Re: **Girder Issue**
Location: Lot 41 Honeycutt Hills (188 Shelby Meadows, Angier, NC)
JDS Project No.: RDU2503287
Date of Inspection: 03/31/25

Observations

sheet:
S2.0

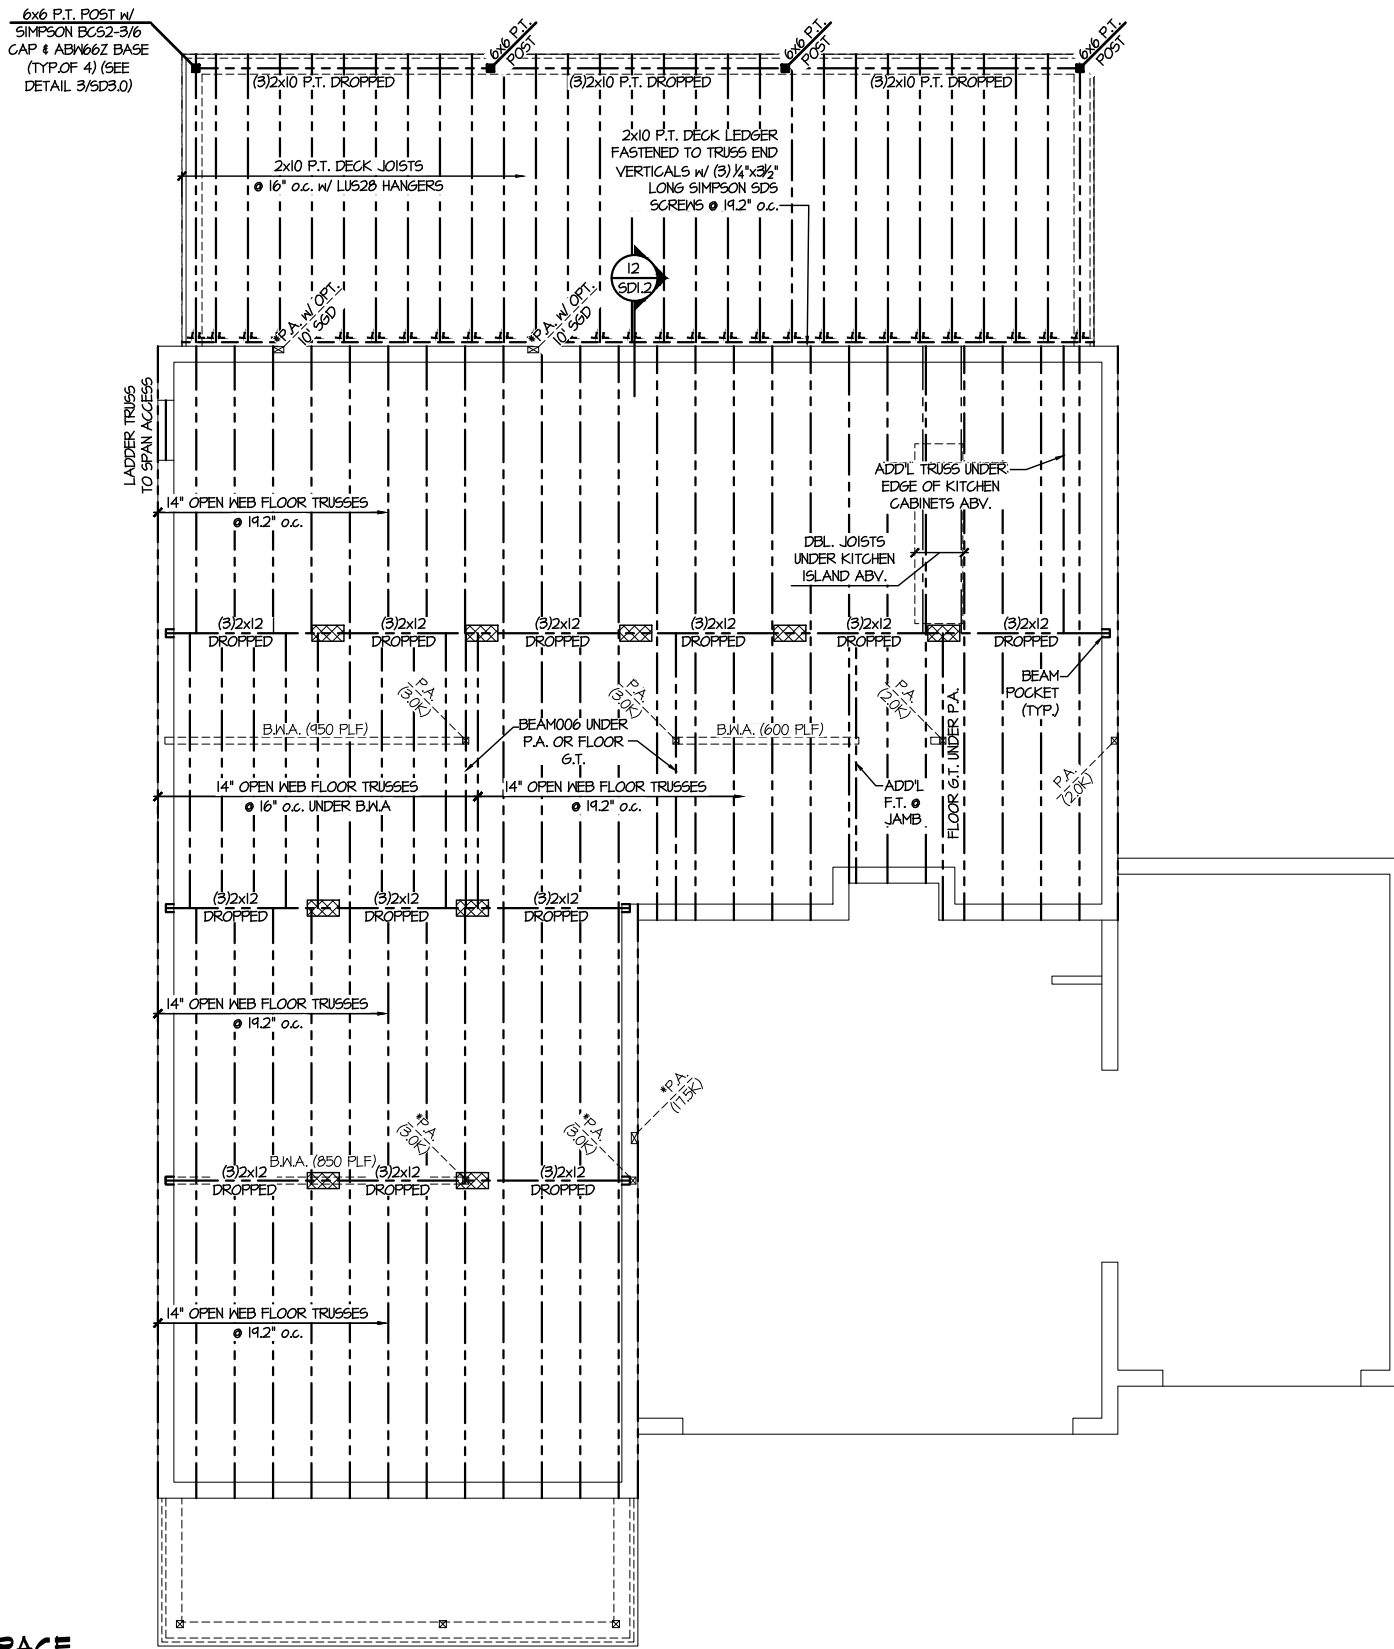
The client requests an evaluation of the 1st left to right girder beam from the crawl space door. The client is questioning the bearing area of the left bearing end. The beam has approximately 1-1/2" bearing of each ply on the 2x bearing block that is in the beam pocket. The bearing block is not fully bearing on the CMU blocking.

1. Support the girder at the left bearing end.
2. Remove the 2x bearing block.
3. Clean cut the CMU block at the girder pocket to provide a flat level surface.
4. Reinstall 2x PT bearing block.
5. Install metal shims at any location of the girder that is not fully supported.
